Case Officer: Rebekah Morgan**Recommendation:** Approve**Applicant:** Bicester Motion**Proposal:** Variation of Condition 3 (plans) of 19/02708/OUT - To vary the approved parameter plans**Expiry Date:** 12 October 2023

Title
Indicative Layout Plan (S73)

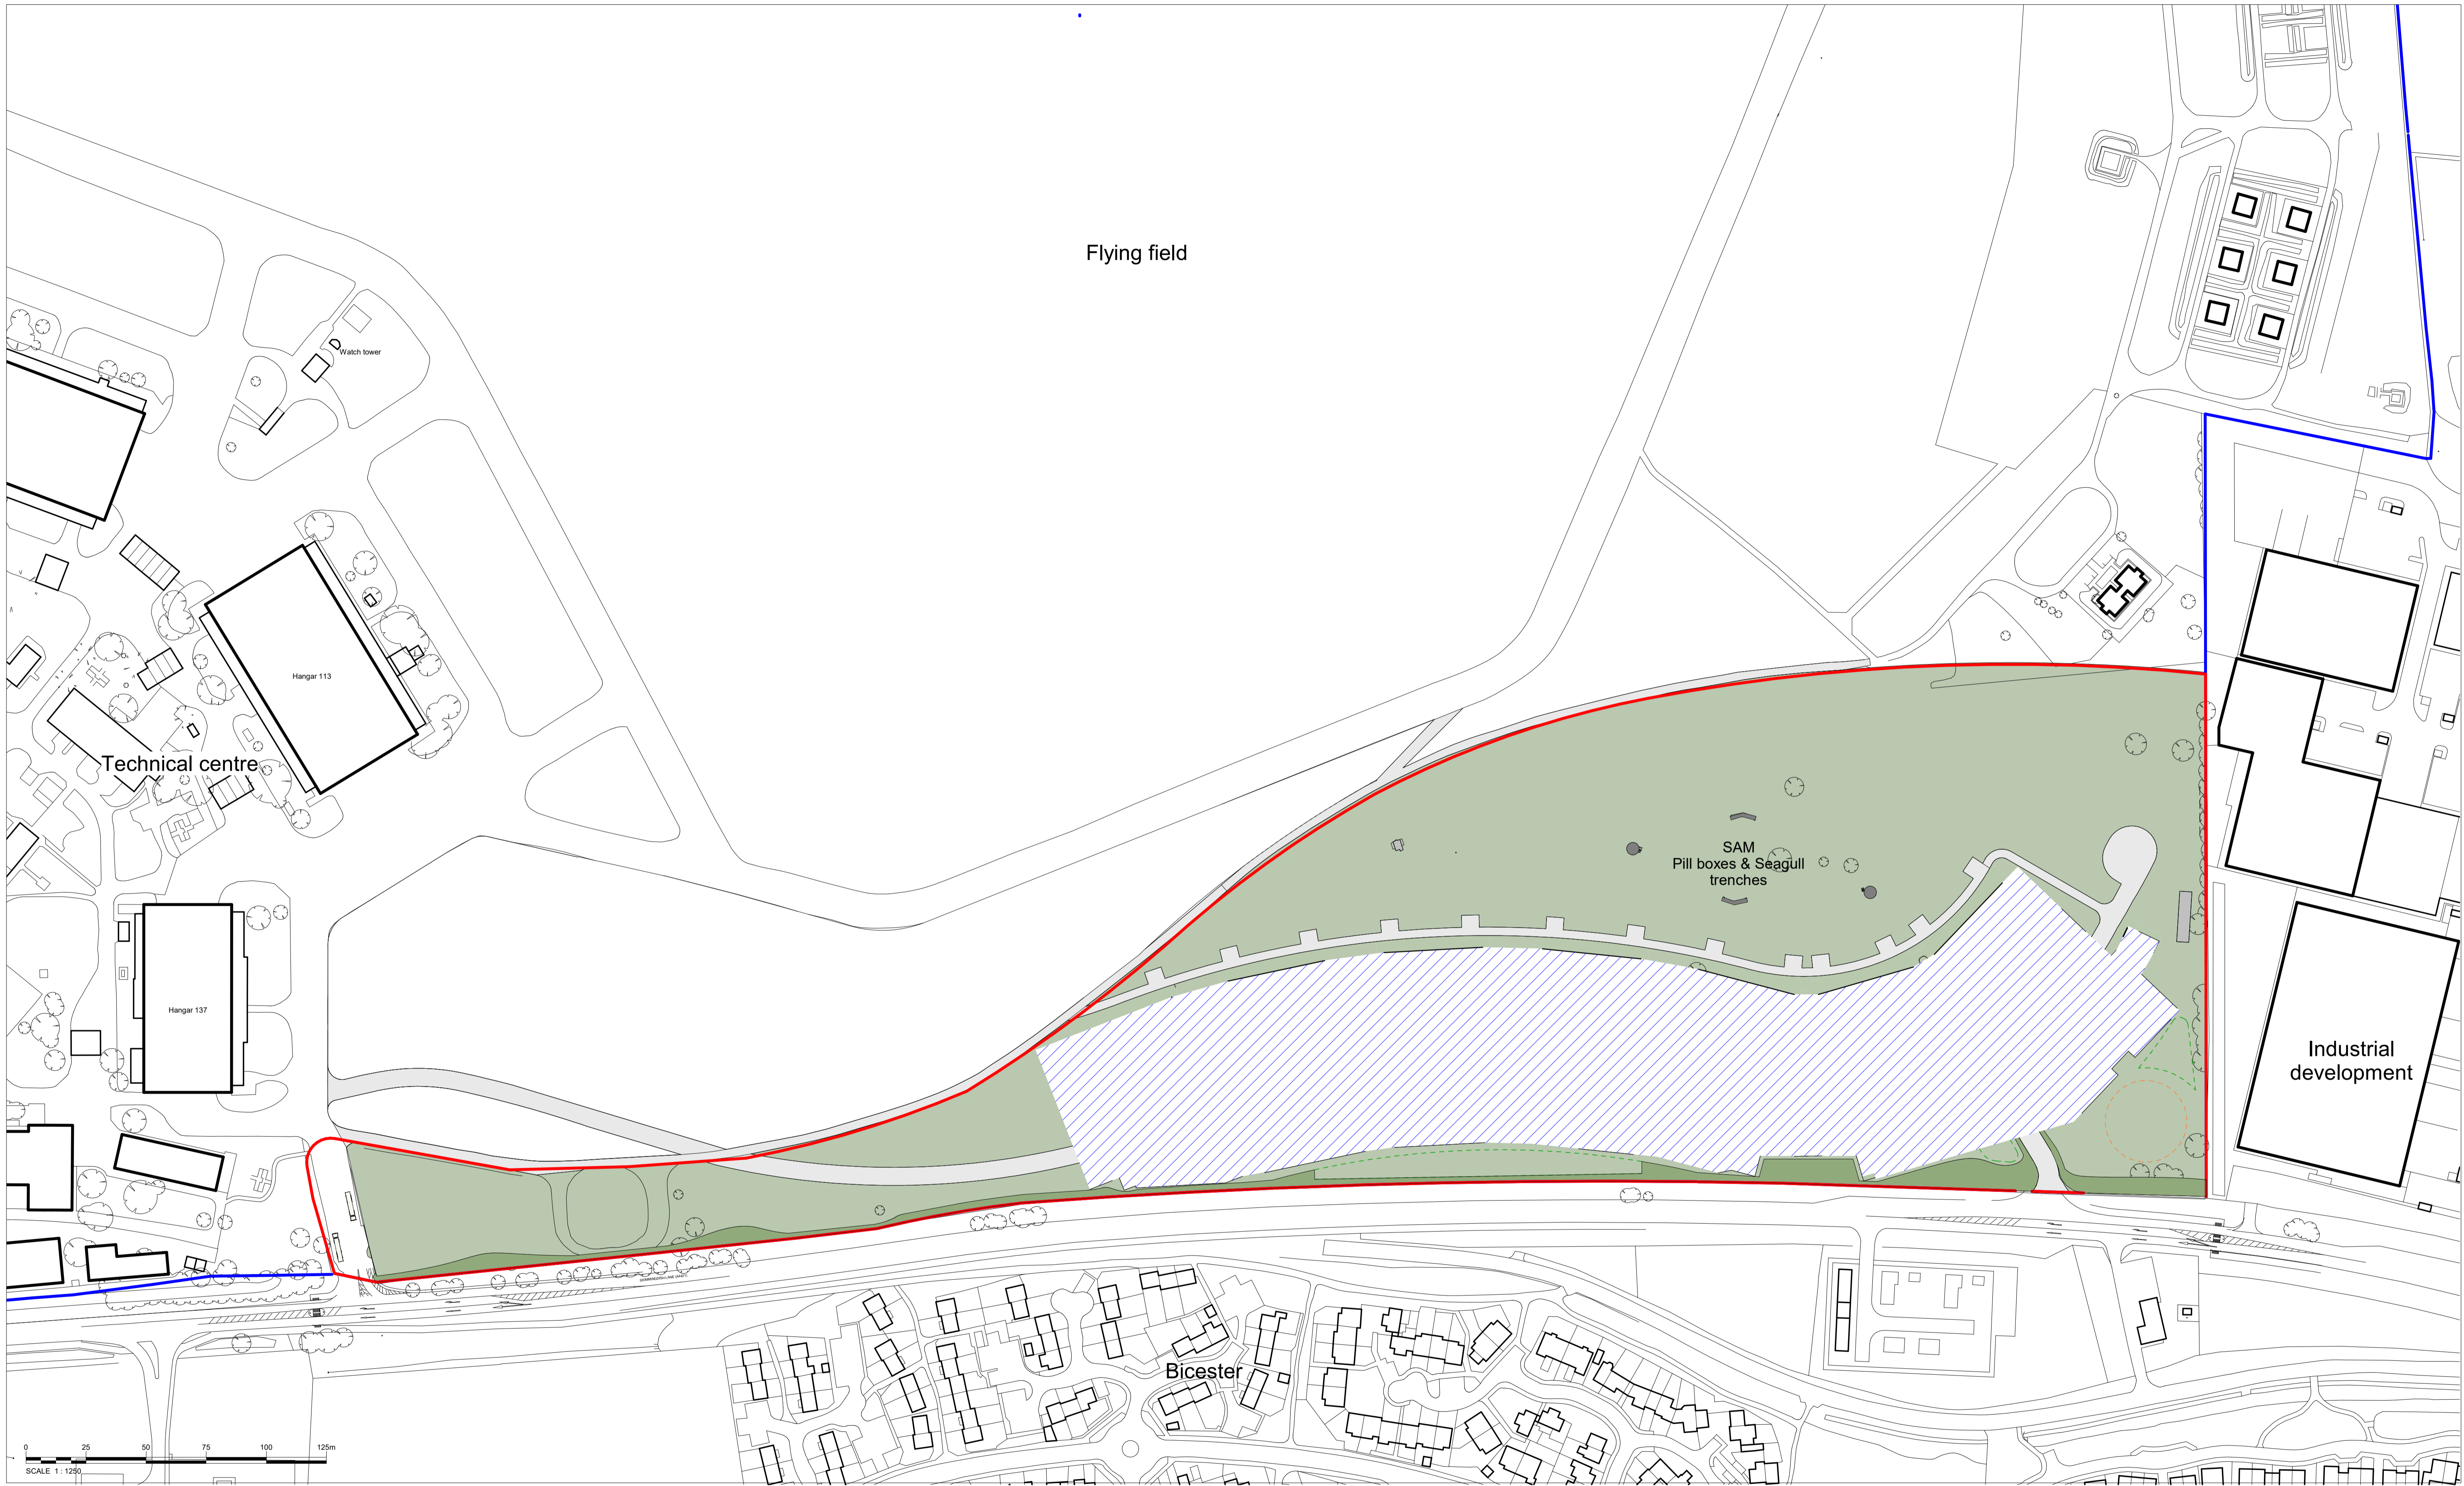
The previous layout, as shown on 5002854-RDG-Z05-ST-PL-A-0094 (Rev.K) submitted with the application indicated a row of buildings with gaps between them,

with the option of connecting the buildings with ground floor structures or first-floor 'bridges'. This might have allowed some understanding of the open area that would have existed when the south-west facing seagull trench was constructed, through a gap between two buildings. In contrast, this current proposal reduces the spaces between buildings. This effectively removes all sightlines from the seagull trench towards the south-west, placing a building directly in the field of fire of the south-west seagull trench.

The current proposal does remove the area of car parking which was originally proposed which would have been located between the scheduled monument and the neighbouring scheduled bomb stores, and that does represent some benefit. But in our view, the current proposal could represent an increased level of harm compared with the previous, established, layout, through the removal of any potential appreciation of the south-west aspect.

- The potential level of parking set out in the revised parameters plan (401 spaces) exceeds that which was approved under ref 19/02708/OUT (348 spaces) as well as the county council's adopted standards. This increase in parking has not been justified nor its impact assessed.
- The level of cycle parking proposed on the revised plan (88 spaces) is significantly less than previously approved under planning ref 19/02708/OUT (108 stands / 216 spaces).
- The increase in car parking provision and reduction in cycle parking does not encourage sustainable travel to the site and is contrary to policy.

I do not object to the revised parameters plan in principle, however I note that the planning statement sets out that the revised masterplan can accommodate up to 401 car parking spaces. This is an increase on the 348 spaces set out under the approved application 19/02708/OUT and is significantly above the level set out in

The level of cycle parking proposed on the revised plan is also significantly less than approved under ref 19/02708/OUT and significantly less than the level set out in the recently adopted Parking Standards document. This would also lead to greater car dependency. The previous permission set out the provision for 216 spaces.
